**RE: Exhibition of State Significant Development for the Redevelopment of Australian Technology Park, Locomotive Street, Eveleigh (SSD 7056)**

The Heritage Council Approvals Committee considered the matter at its meeting on 2 March 2016 and resolved that the Executive Director, Heritage Division, as delegate of the Heritage Council, provide the following recommended conditions of consent:

Figure 9 – Building 1 (foreground in white) and Building 2 (background in white)
 Source: FJMT + SISSONS Architects

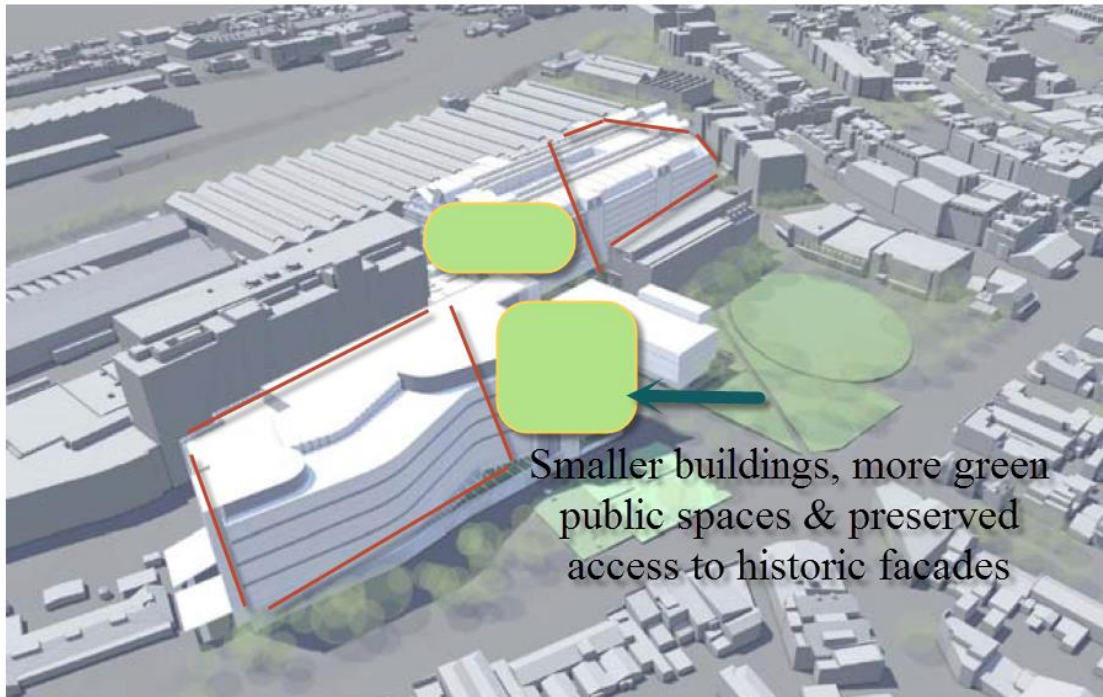
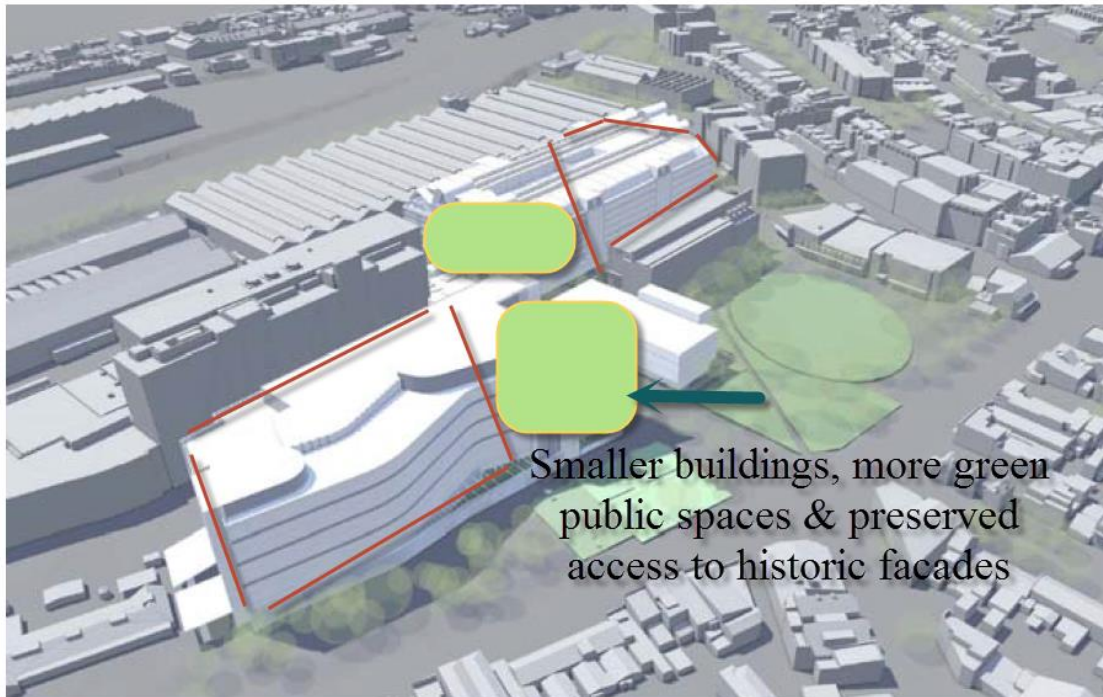
1. The proposed alignment of Building 2 along Locomotive Street creates a streetscape that will give primacy to the new building, diminish the scale and visual setting of the former Locomotive Workshops, and does not comply with setback requirements of the Redfern Waterloo Built Environment Plan 2006 and the policies of the endorsed CMP. The design should be modified during the detailed design stage to provide an appropriate setback from Locomotive Street. The extent of the setback should be established in consultation with the Heritage Division.
